Gates at 113 Newbury/40 Hancock

I have started review of the application to add a security gate to the entrance of 113 Newbury, Unit 104.

JOB: 113 NEWBURY STREET / ORNAMENTAL GATE FRAMES | SK-1 | JOB NO.3751

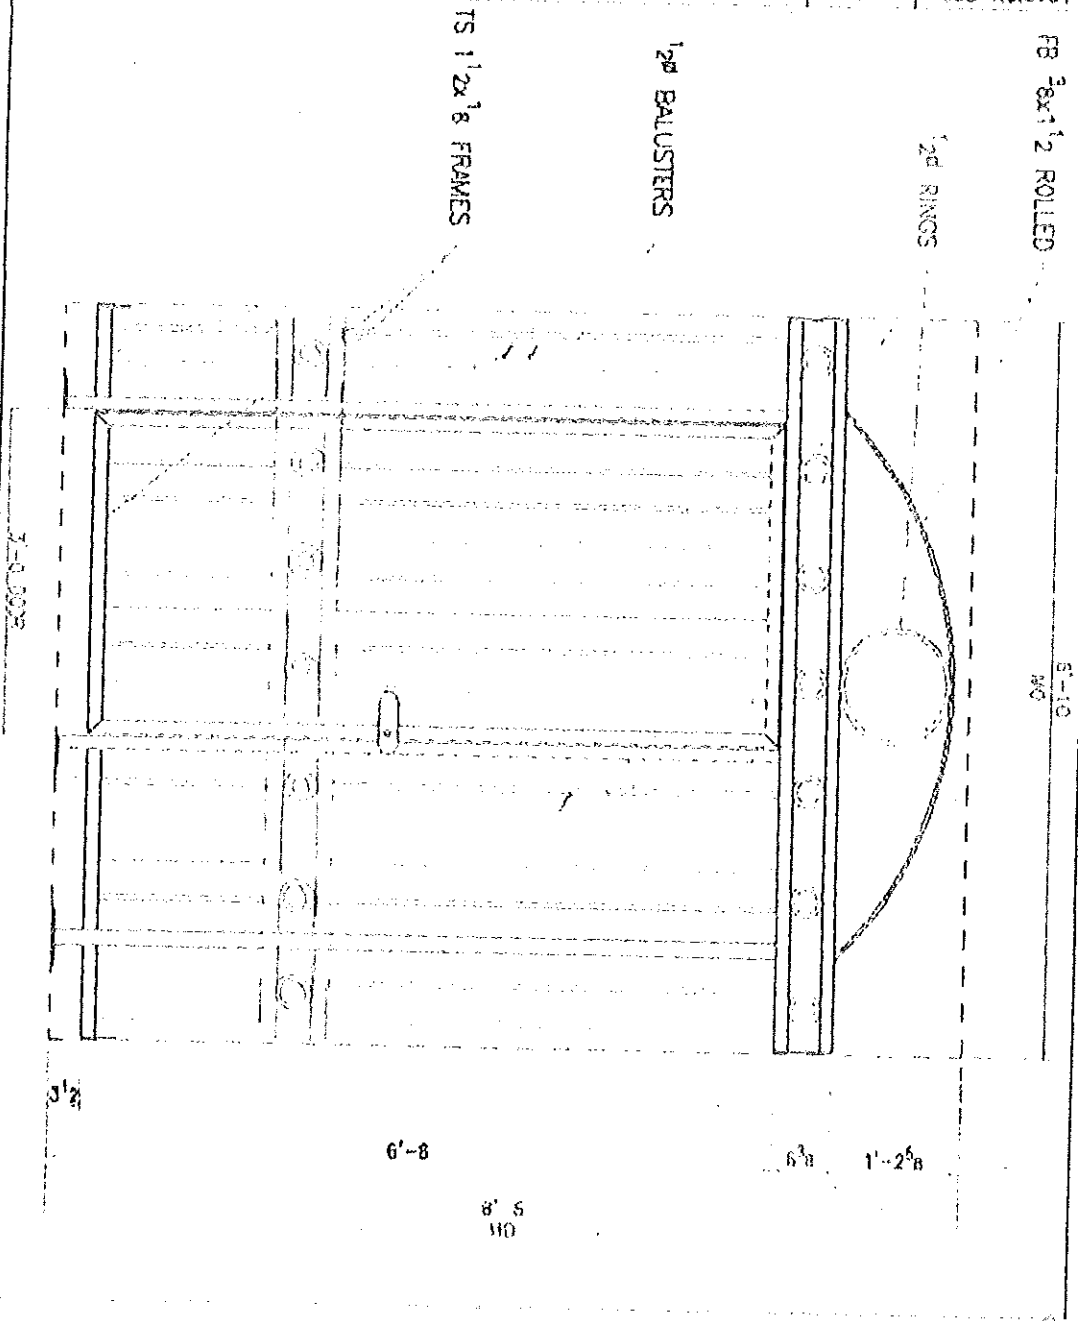
I checked with Nell Donaldson in Planning, since the building was subject to design review during the planning board approval process. She said that the gate is fine, as long as all gates that will be installed are the same design. From the application, it appears that this is your intent, but I just wanted to put in writing that we will require this of future applications.

I am signing off for zoning, and the application will next be reviewed for building and fire code compliance. This is necessary because the gate needs to comply with egress requirements. Those reviewers may need more information on the functionality of the gate such as whether there will be panic hardware for exiting, but I will let them contact you directly with exactly what they need.
